**Project No: PR-2023-008674   Date: 1/08/2025   Agenda Item: #2   Zone Atlas Page: H-11**

**Request: Final Plat for Playa Del Sur**

**Project Name:** Playa del Sur Subdivision

**Requests:** Final Plat; subdivide 1 tract into 4 tracts and 77 lots

**Plat for
Playa Del Sur
Being Comprised of
Portions of Tracts 308, 309 and
310, Unit 8, Town of Atrisco Grant
City of Albuquerque
Bernalillo County, New Mexico
January 2024**

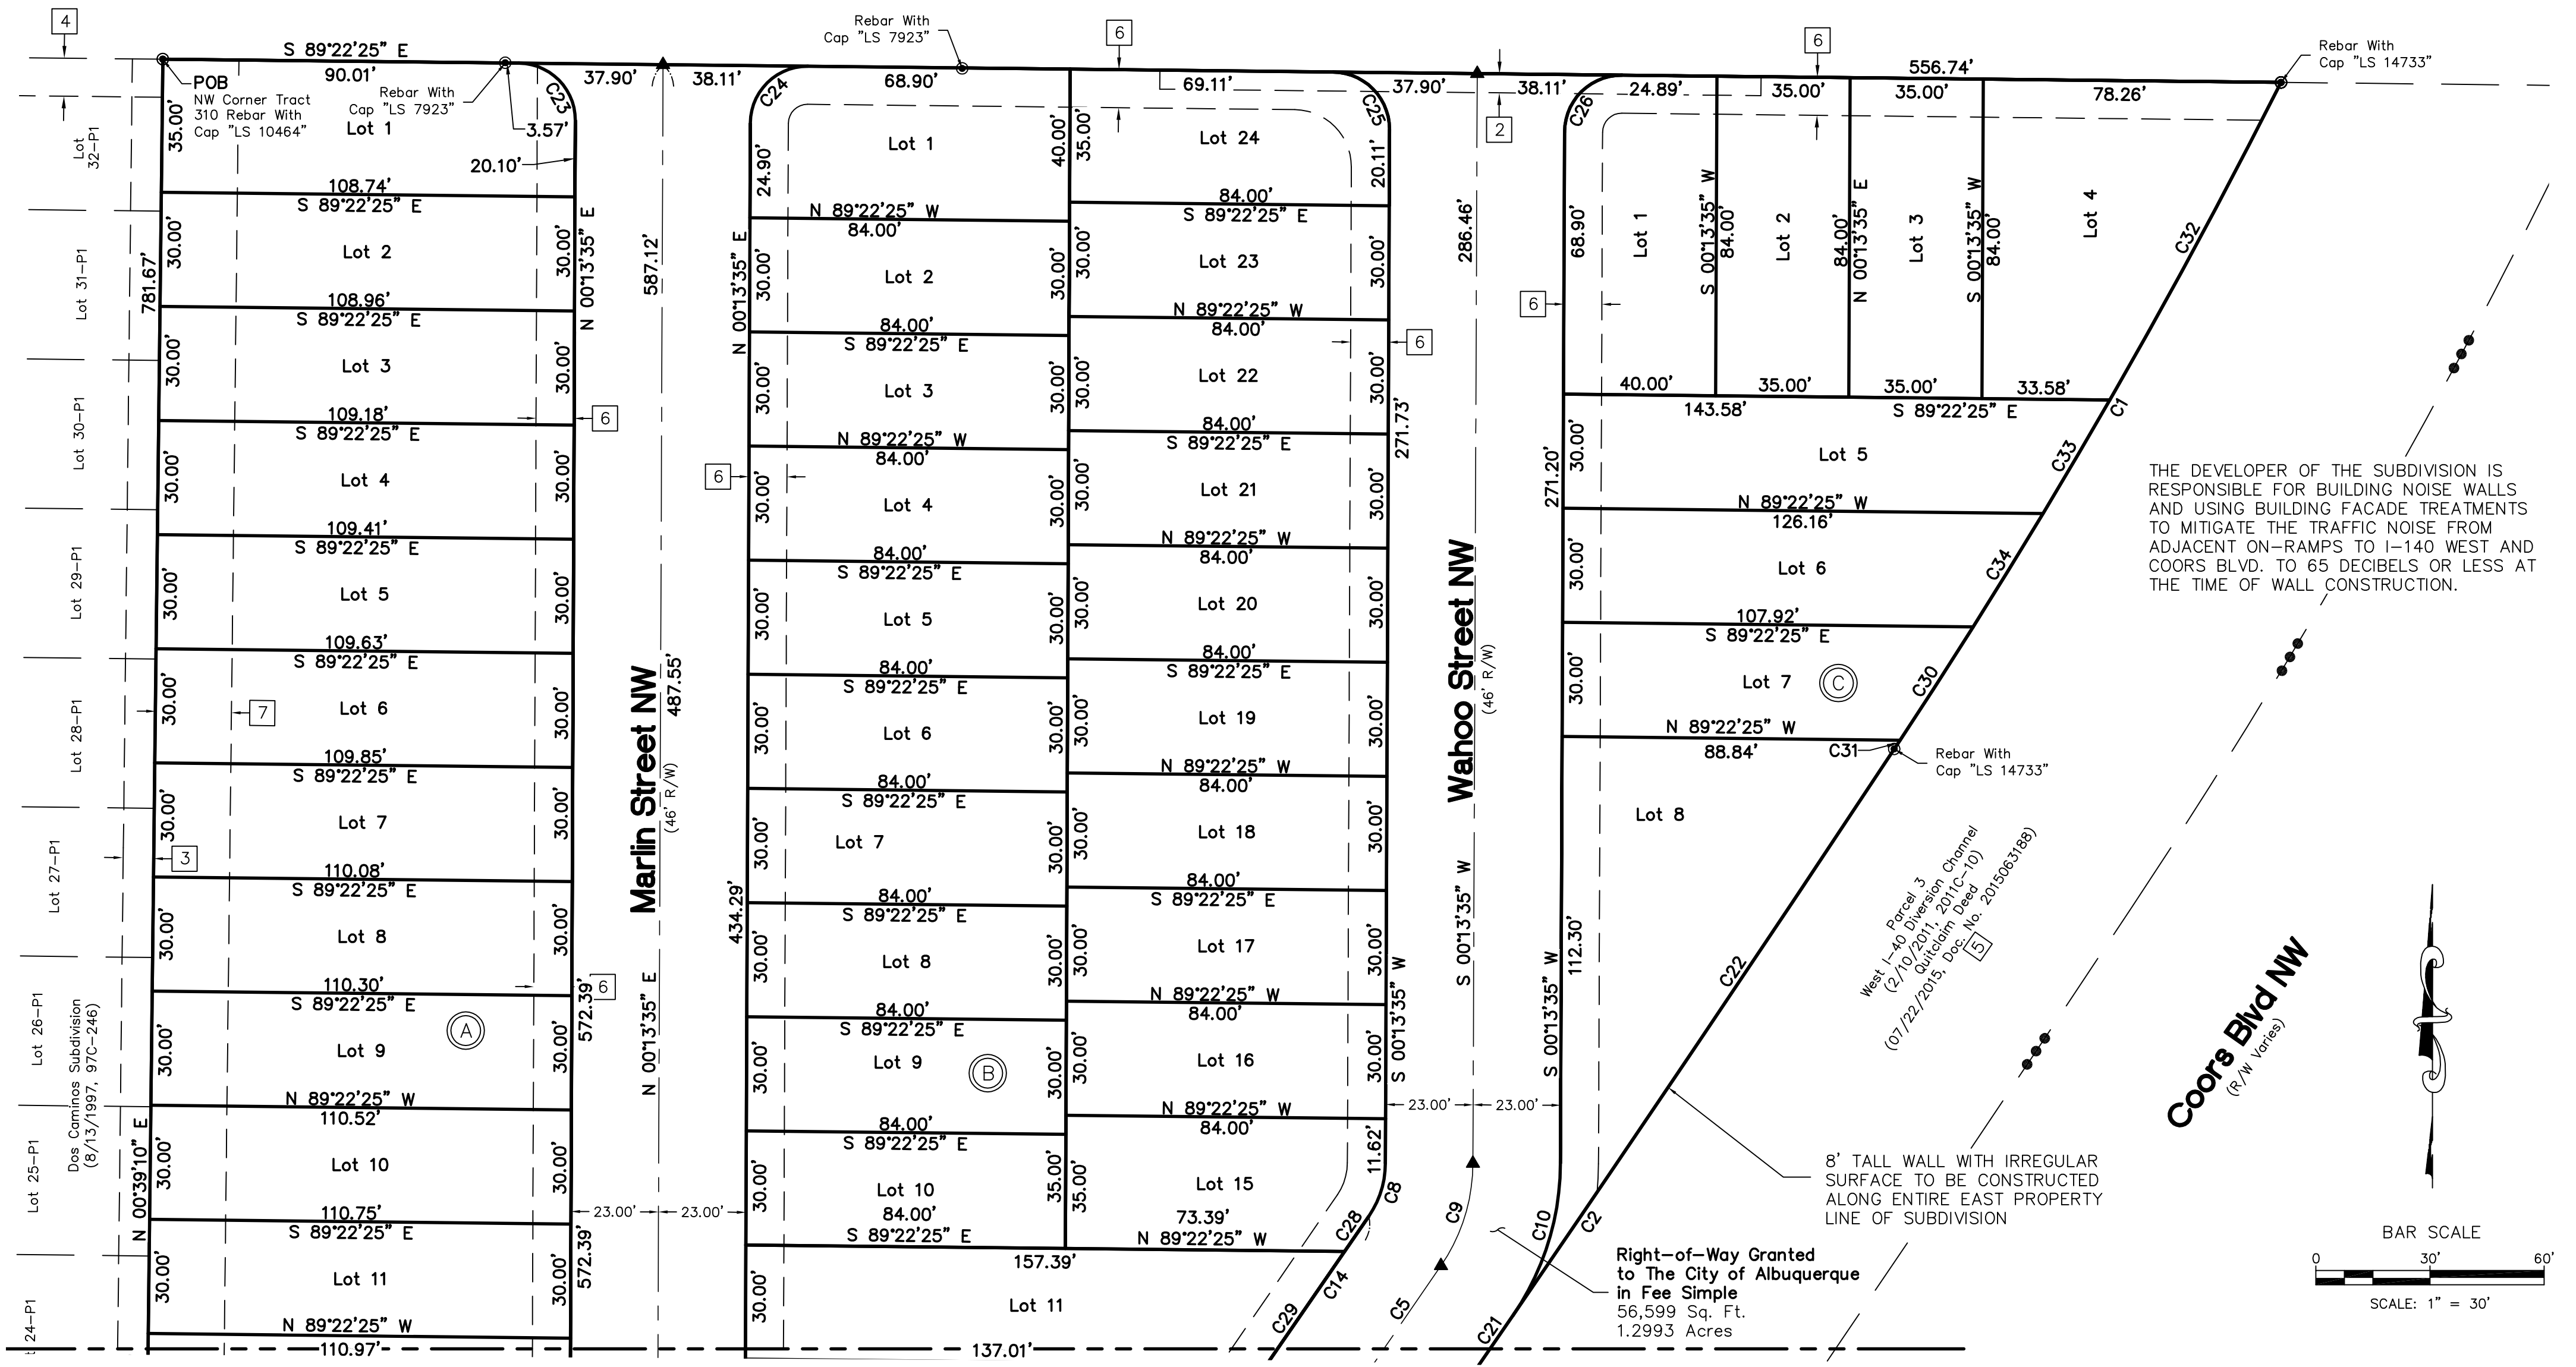
- c. Show on the Plat that an 8-foot wall, no less than 6 inches wide, with an irregular, not flat, surface that bounces noise, possibly split face block, will be built along the entire eastern property boundary and to wrap around the corner with Lot 4 on Miami Road for a distance of 35-50 feet, stepping down as it approaches the front façade.

This condition is partially met with a label for this wall on Sheet 3. Please modify to the exact language above which includes 6 inches wide and the wrap around the corner with Lot 4 on Miami Road for a distance of 35-50 feet, stepping down as it approaches the front façade. This note must be added to Sheet 4 as well.

STRUCTURAL NOTES

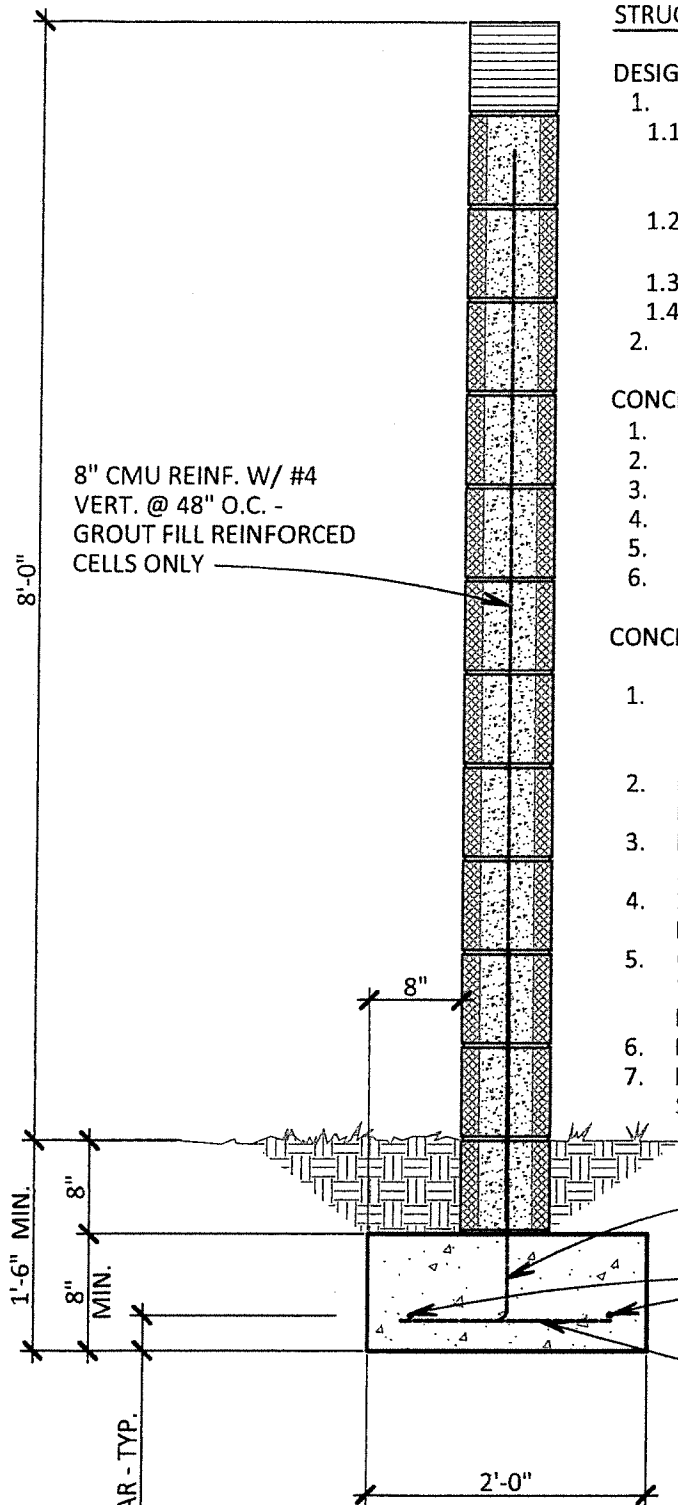
Confirm that the wall drawing on the wall permit document shows at least a 6-inch-wide wall.
